Subject: RE: P/70/19/RES - Summer Lane, Pagham

Subject: P/70/19/RES - Summer Lane, Pagham

Appendix (C)
Proposed Site Layout

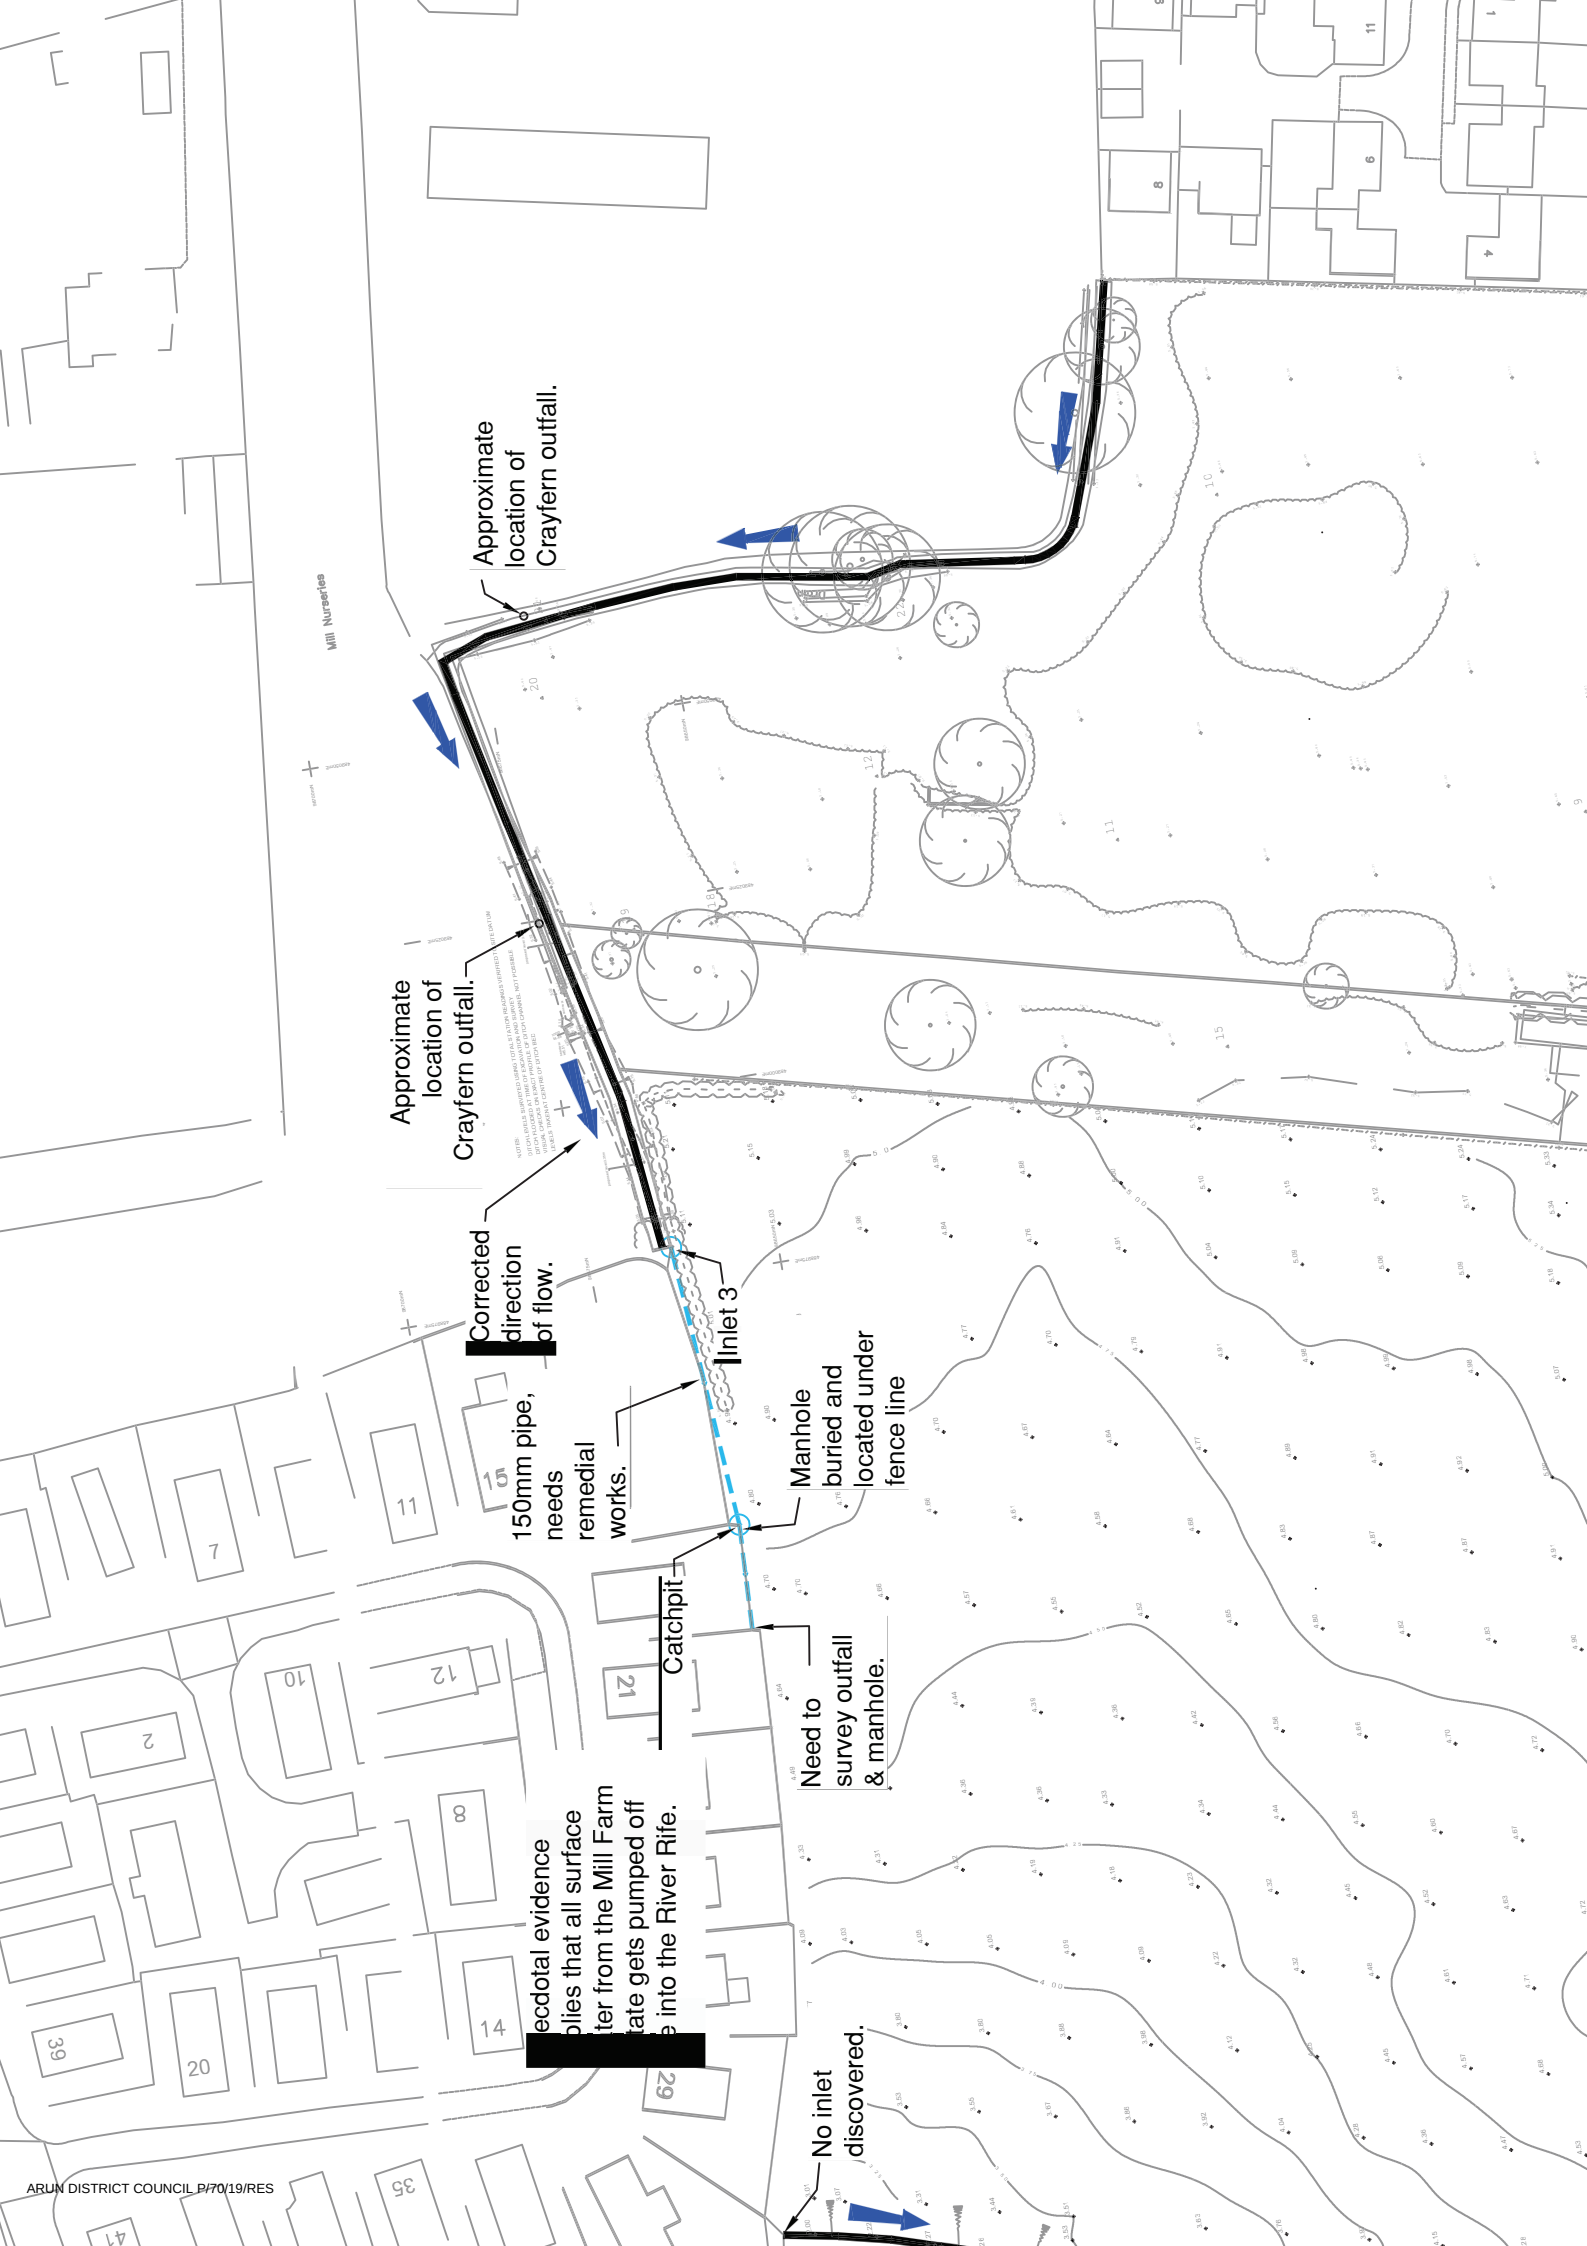
Thank you for your further response. I consider the approach to parking is sensible. I do not consider that the bin collection points are clearly indicated on the drawing but I have now located at least 3 of these small rectangular areas on the plan so that is fine. I have replied to the Parish with your responses and to say that I agree that no further screening of bin stores is required. I have also forwarded your responses to Highways.

- (1) Can you advise which plan the bin stores are shown on. I cannot see any on the site plan and I'm working from home today such that opening plans on the laptop is taking longer than they would in the office.

- The plans do not show **bin storage** as such and we assume that the initial comment was actually in relation to the bin collection points on the Site Plan. The design relies upon bins being stored in the respective gardens for each property. The collection points are only there for use on days when the bins are to be emptied and are a temporary location in which the bins can be "parked". These are required to comply with maximum pull distances for the bins by operatives to the refuse vehicles, which have a maximum reversing distance. The collection points are just a level area/ hardstanding but visually softened where possible by planting. Of the four collection points, three are screened by tree-planting. As a self-contained development we do not see that there is a need to provide anything more in this regard.
